By email
19 November 2025

Our ref: 298160-00

Crows Nest Over Station Development (OSD) Site B **Ventilation of apartments**

Sheet title  
CROSS VENTILATION

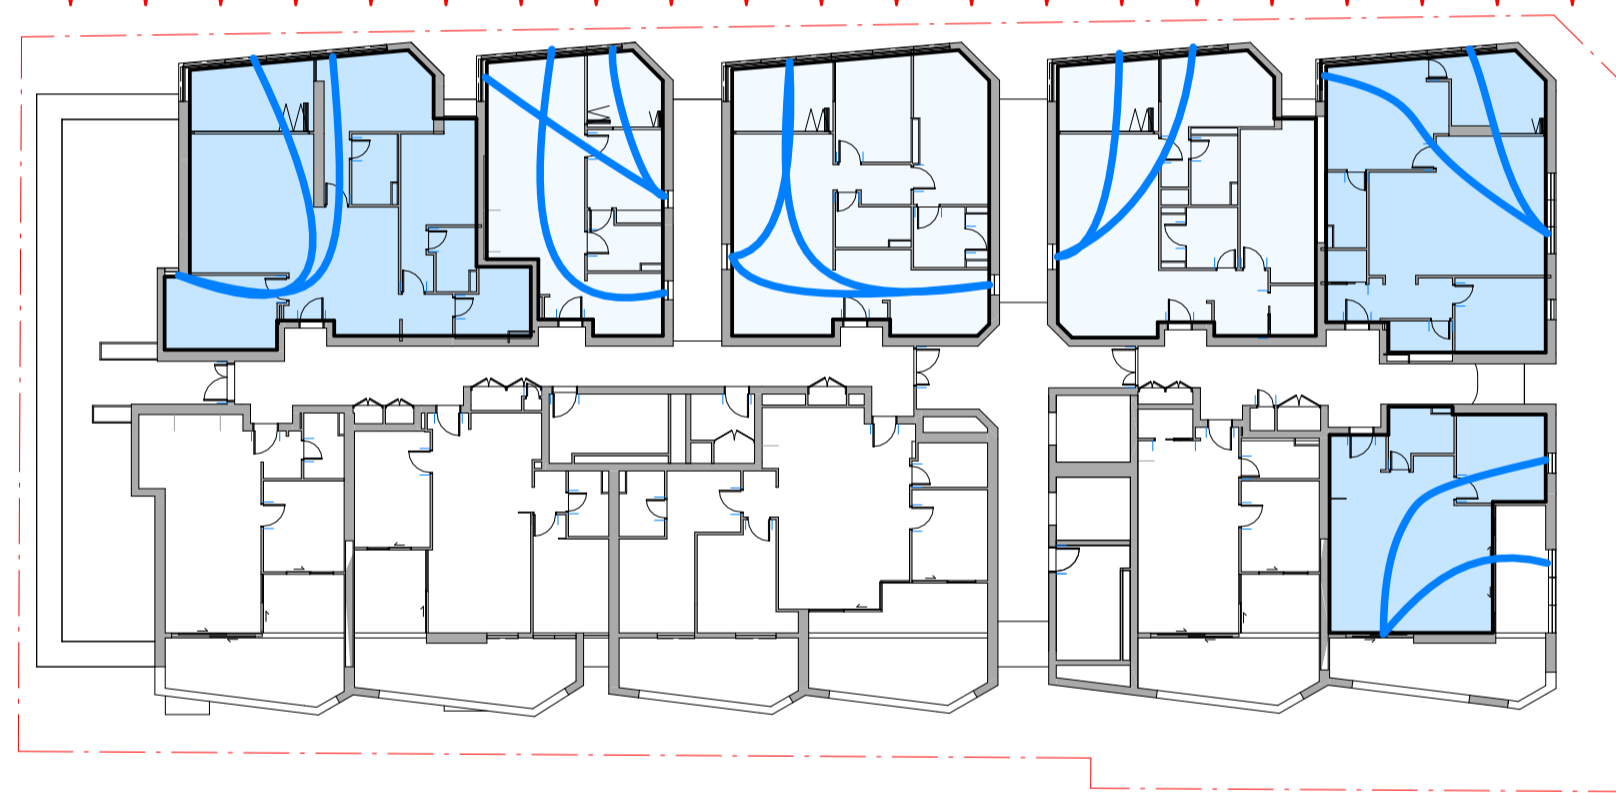
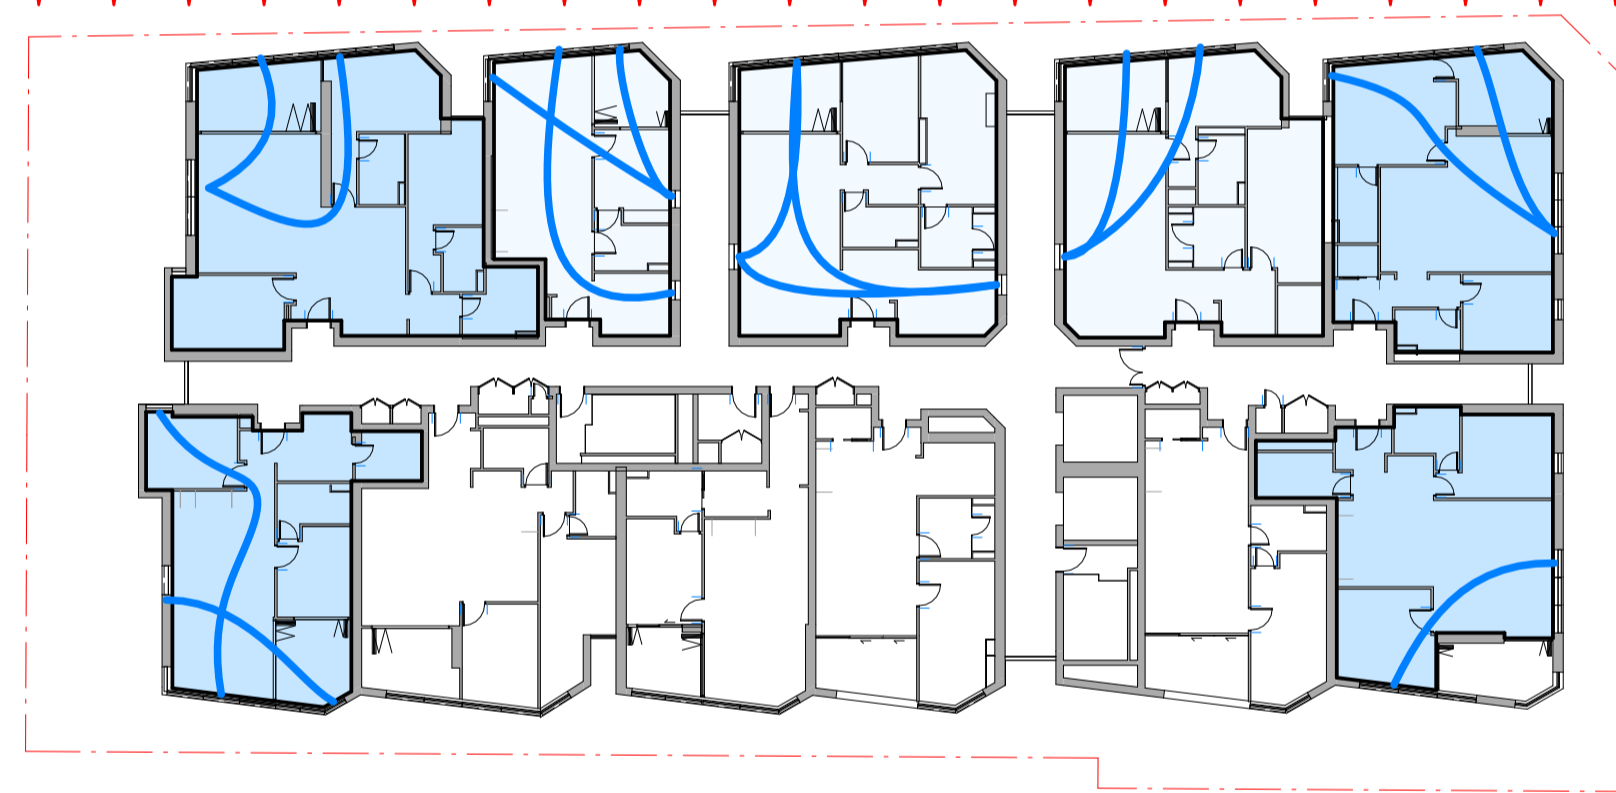
This letter addresses the comment from the Department of Planning and Environment on 11 November 2025, specifically concerning the three central apartments on Pacific Highway aspect that do not meet the Apartment Design Guide (ADG) regarding cross-ventilation. Arup provides this letter regarding the ventilation of these apartments, Figure 1.

The site is exposed to prevailing winds from the north-east, south and north-west, creating differing pressures at the apartment openings on the external façade, and also on openings within the naturally ventilated corridors. The quantitative pedestrian wind assessment by Arup (2025) demonstrated that air flow through these corridors would occur for a range of wind directions. Given the differing wind conditions on the external façade of the site and within the corridors at any given point, depending on the wind direction, there will be pressure differentials between the various façade openings on the three apartments under review (Figure 1). As such, these apartments have the potential to be ventilated, if occupants choose to do so. The level of ventilation would need to be confirmed through quantitative analysis. However, as per the letter by CPP (2025):

“With the minimal pressure difference required to induce sufficient air flow to meet minimum air quality ventilation requirements, the size and location of the external openings on the articulated façade of the Level 8 and 9 apartments would be expected to meet the design intent of the ADG.”
